Rezoning Transportation Analysis

Petition Number: 2020-038

General Location Identifier: Tax ID 20143102

Date	Description
04-22-2020	First Review (EL)
05-19-2020	Second Review (EL)
06-25-2020	Third Review (EL)
08-20-2020	Fourth Review (KP)
09-17-2020	Fifth Review (KP)

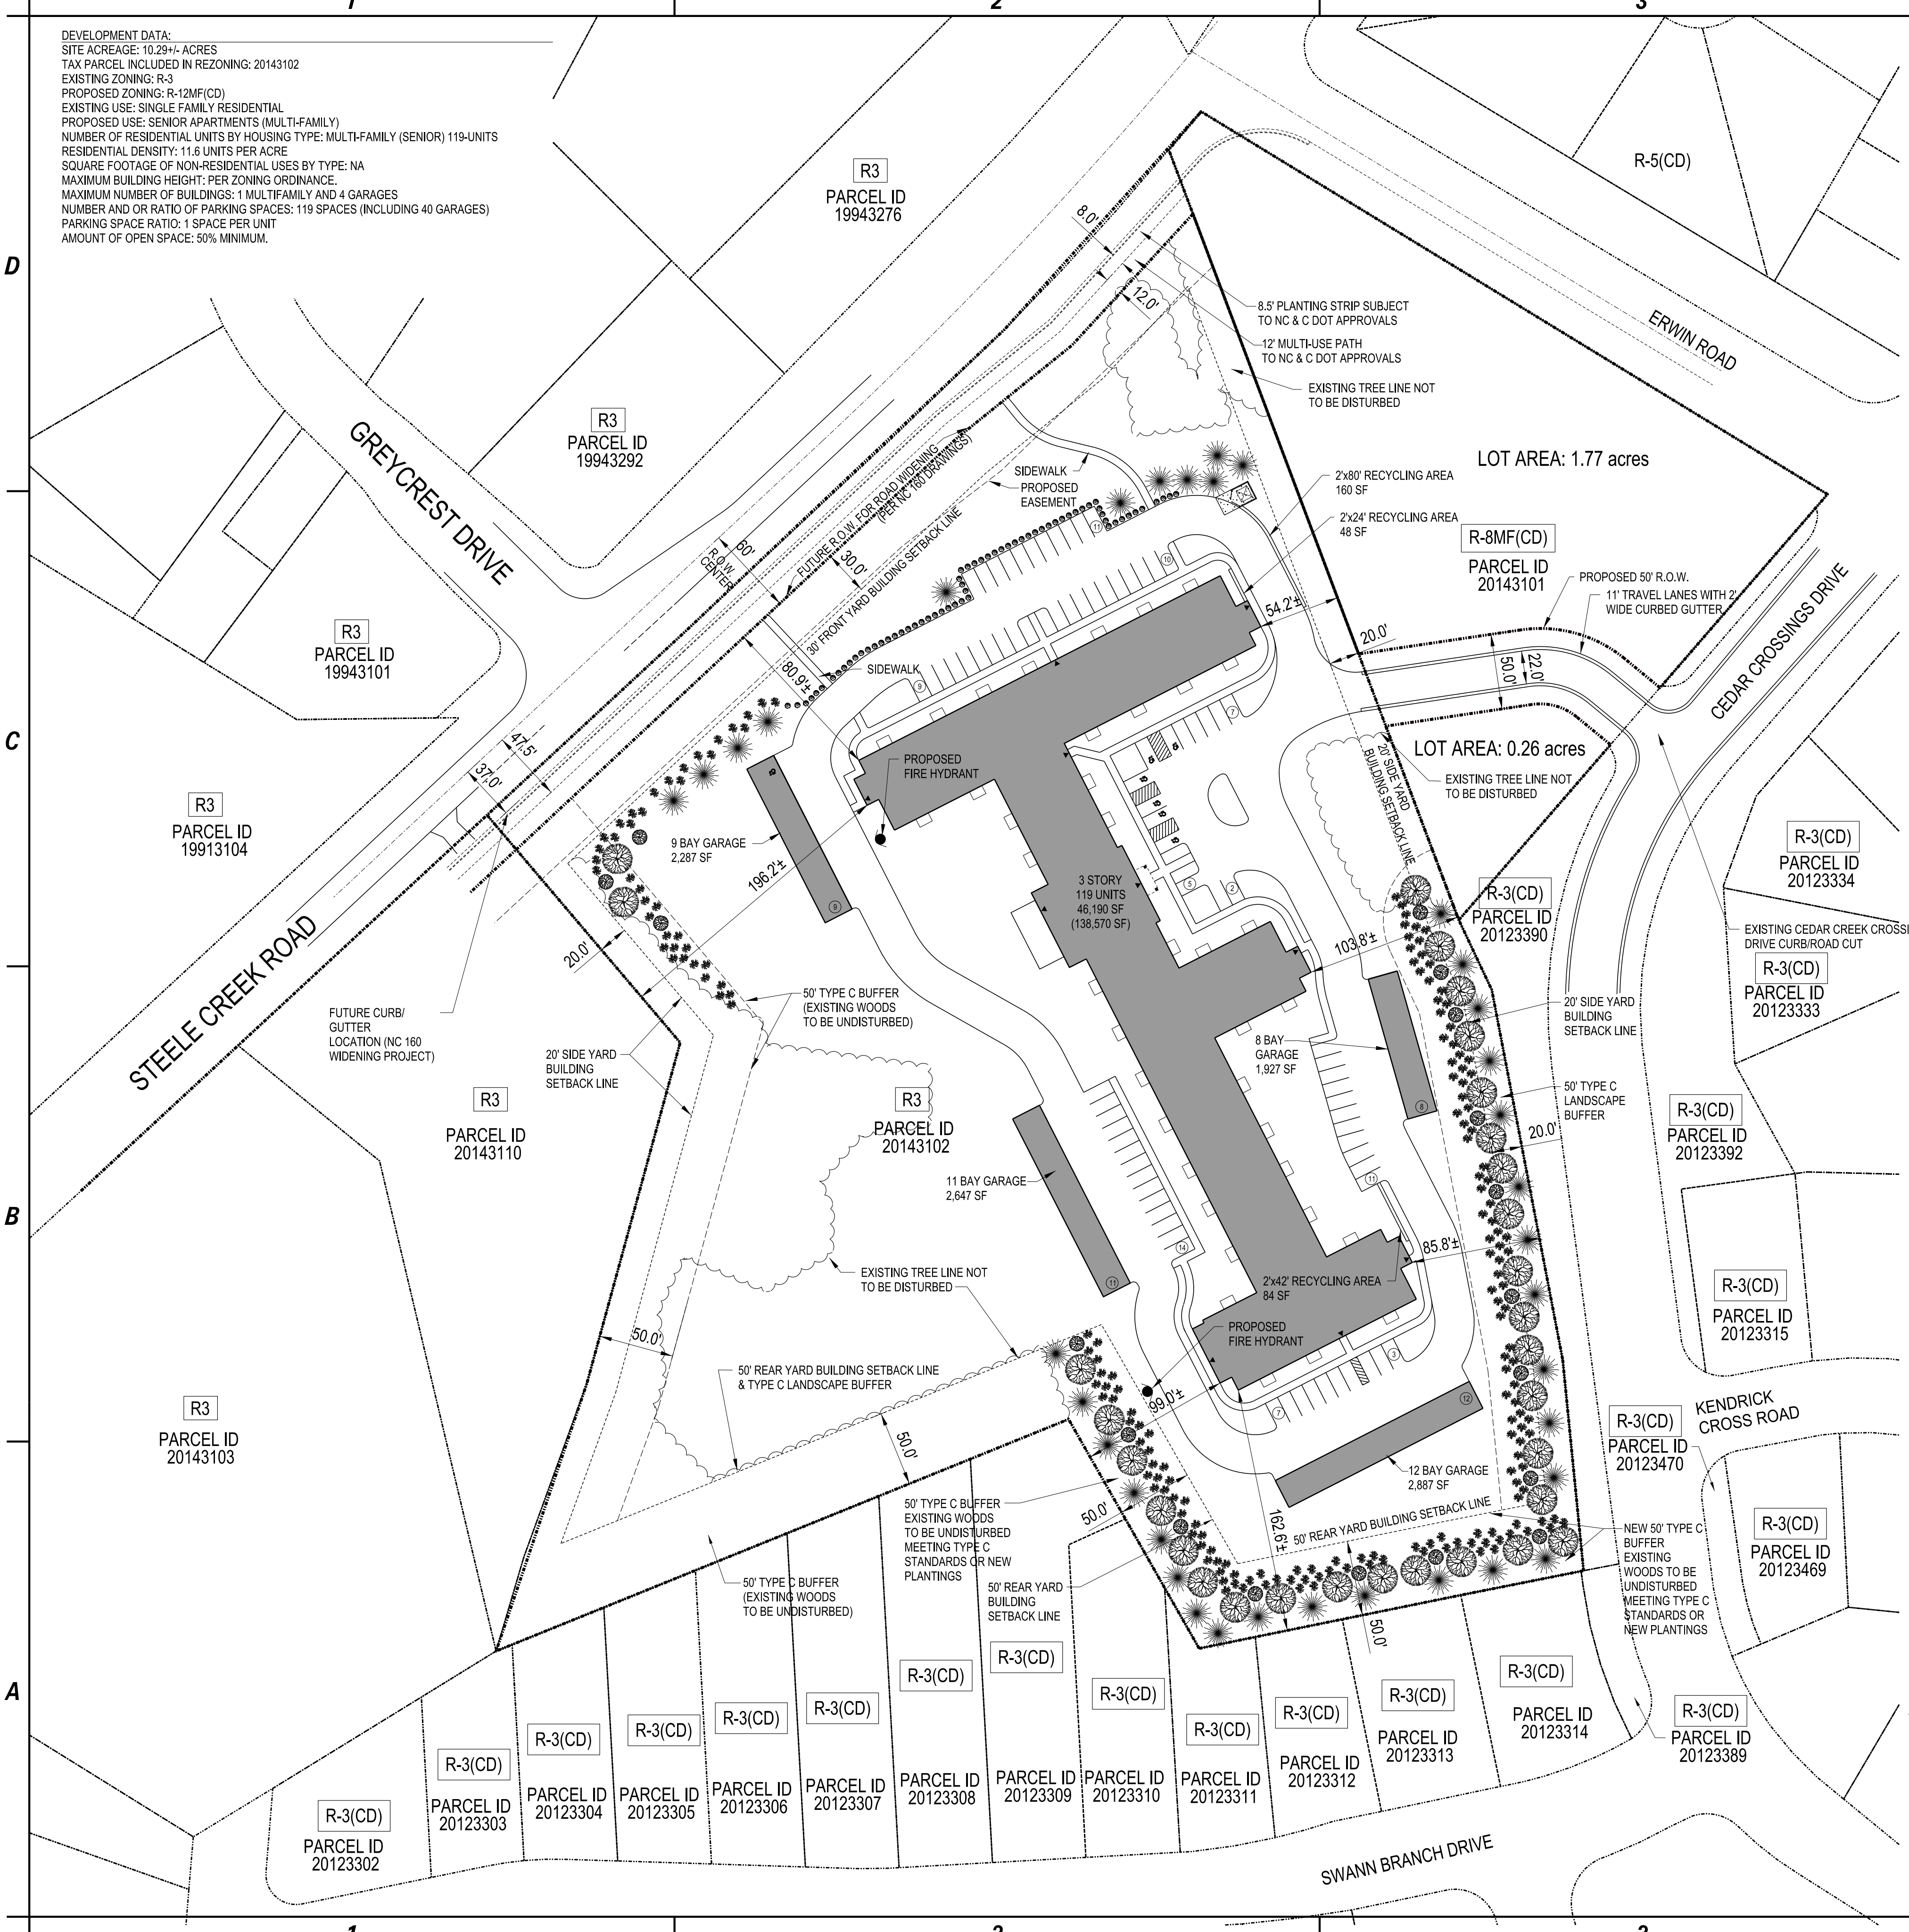
A new site plan with access off of Cedar Crossings was provided on 08-17-2020, requiring a substantial review. This site plan needs revision to address updated comments, outstanding comments, and new comments based off of the new site plan. These include labeling and dimensioning a right-turn lane. Please note that all CDOT reviews have included a comment to add a left-turn lane onto Erwin Rd to help ease congestion in the area, however, this is not a requirement for approval and has not been agreed to by the petitioner.

Outstanding with clarifying language added with 08-17-20 site plan: The petitioner should revise the site plan and conditional note ([Section Transportation.7.](#)) to commit to a north-eastbound 100' right-turn lane ~~into the~~ from NC 160 into Erwin Drive. Please clearly label and dimension the right turn lane. **Updated Comment from 09-14-2020 Site Plan:** It appears this right turn lane is there, however, it is not labeled nor dimensioned.

5. **Outstanding** with clarifying language added with 08-17-20 site plan: The petitioner should revise the site plan and conditional note ([Section Transportation.7.](#)) to commit to construct a south-westbound left-turn lane with 150' of storage and appropriate left-turn lane tapers based on the speed limit from NC 160 into Erwin Drive. **Updated Comment with 09-14-2020 Site Plan:** This left turn lane has been requested during every previous review phase and in multiple resubmittal meetings. Both NCDOT and CDOT cannot require this left turn lane and, as a result, the petitioner has opted to not include this left turn lane in their site plan and scope of work. This note is not meant to deter approval of this petition, rather, this note serves to provide transparency of information from previous reviews and discussions between all parties.

13. **New Comment as a result of the new site plan dated 08/17/2020:** The petitioner should update the site plan and conditional notes to show an access easement along the proposed access drive from Cedar Crossing Drive. The petitioner should work with the owner of Parcel 20143101 to obtain this access easement.
Updated Comment from 09-14-2020 Site Plan: Include language in the notes that validation of this easement will be provided to CDOT before final permitting.
